Lake Lothing
**THIRD
CROSSING**

**Document 7.5:
Design Report**

**Part One
Design Council CABE Feedback**

Workshop 1: 22nd March 2017

SOUTHERN ROUNDABOUT CROSS SECTION H-H
 WORK NO. 2
 WORKS PLANS SHEET 2
 CHAINAGE 0m
 Horizontal Scale = 1:100, Vertical Scale = 1:100

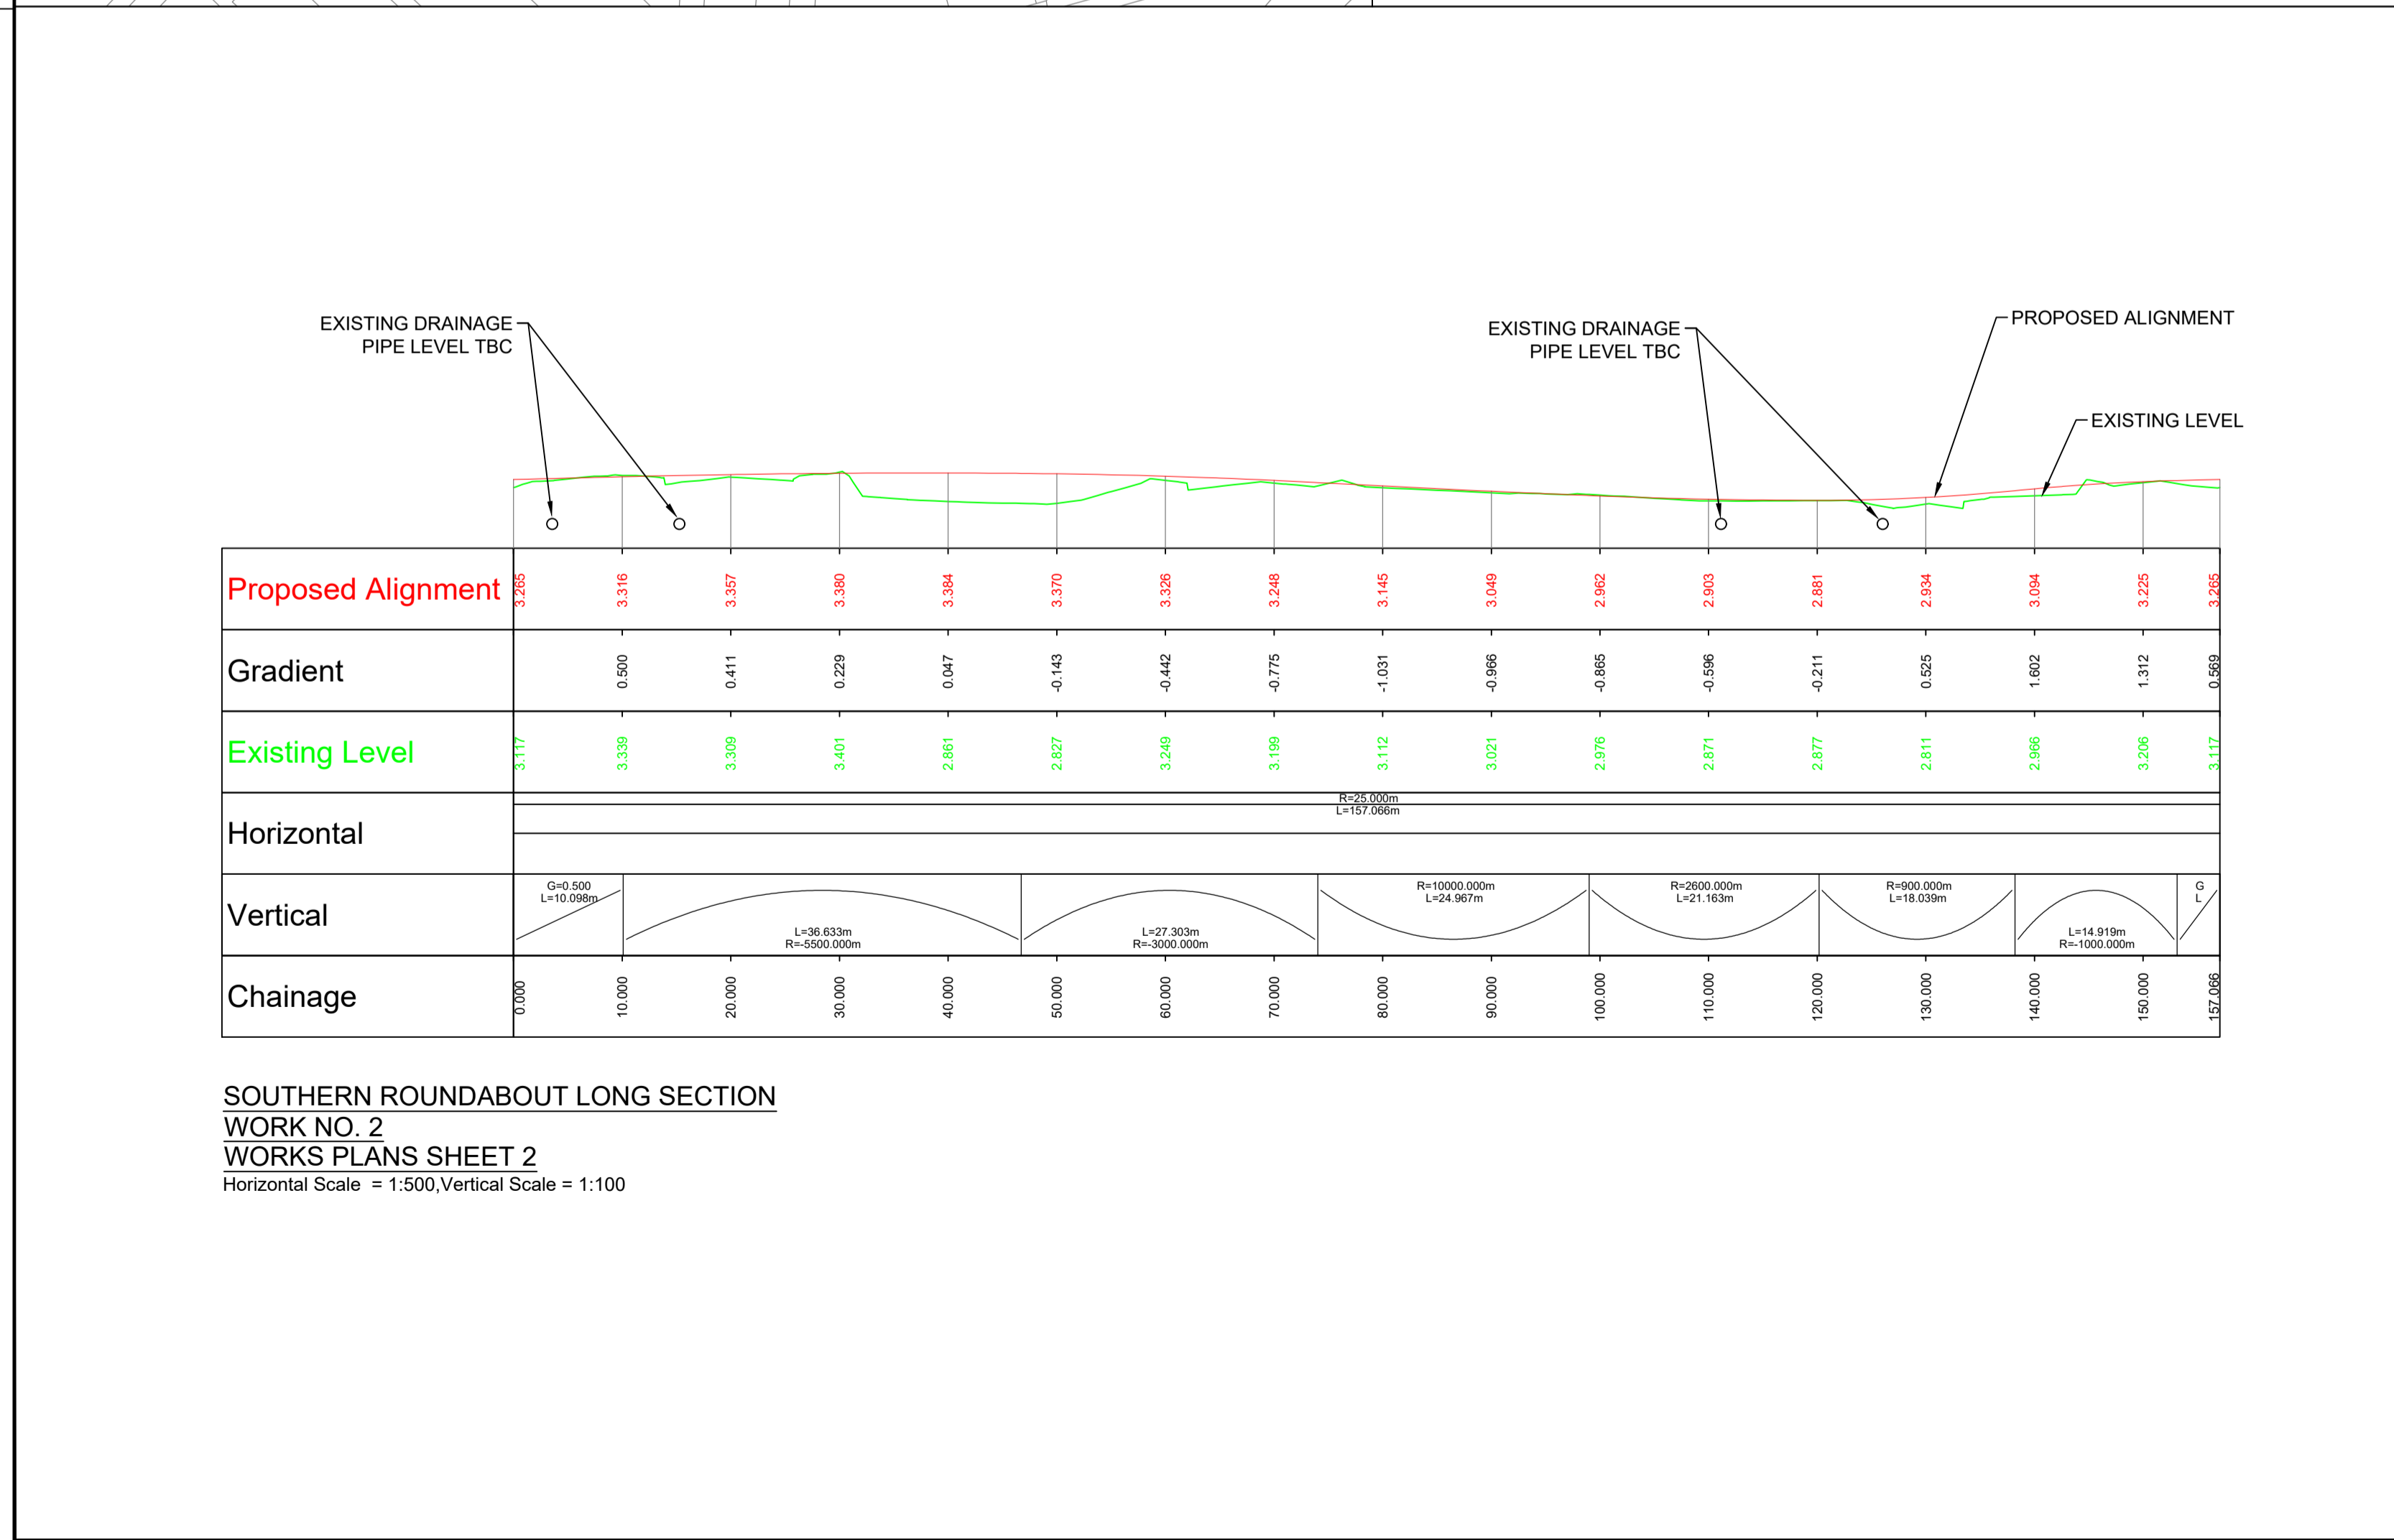
The proposed land take by the roundabout is significant and we encourage the design team consider whether this can be reduced to improve the quality of the urban environment.
